Ribble Valley
Borough Council

My reference: 3/2026/0399
Direct Dial: (01200) 425111
www.ribblevalley.gov.uk
Email: planning@ribblevalley.gov.uk
Date: 30 July 2026

Location: Samlesbury Aerodrome BAE Systems Operations Ltd Myerscough Smithy Road Balderstone BB2 7LF

Proposal: Approval of details reserved by conditions 7 (SW drainage), 8 (construction SW management) and 11 (landscaping scheme) of planning permission 3/2025/0852.

TITLE: **PROPOSED DRAINAGE LAYOUT**

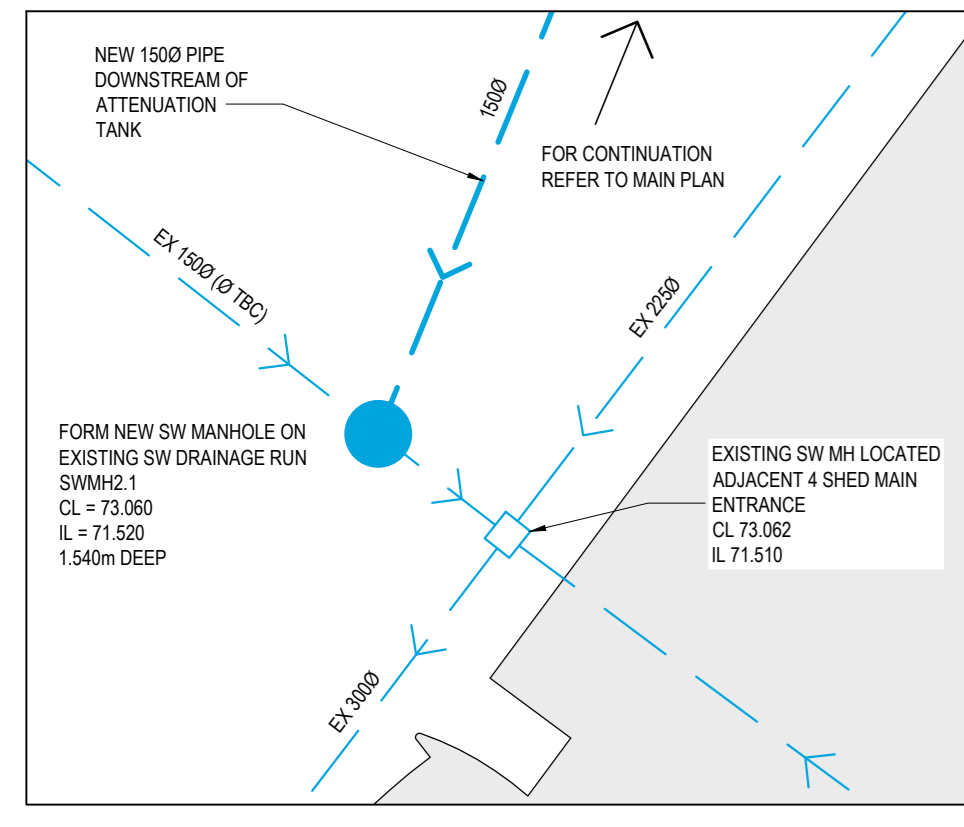
Condition 7 (surface water drainage), as recommended by LLCC LLFA, cannot be discharged as insufficient details have been provided, in respect of:

- No evidence has been provided demonstrating a 40% climate change allowance applied to the 1in30 year event.
- Limited evidence provided to support the proposal that approximately 20m³ of surface water to account for measures to manage the first 5mm of rainfall can be incorporated within the proposed attenuation tank.
- No drainage calculations have been provided that account for the appropriate coefficients and other parameters.
- No evidence of measures to manage the quality of the surface water runoff to prevent pollution and protect groundwater and surface water bodies. The strategy shall include a water quality risk assessment, proportionate to the pollution hazard and sensitivity of receiving waters, and shall inform the design of an appropriate SuDS management train.
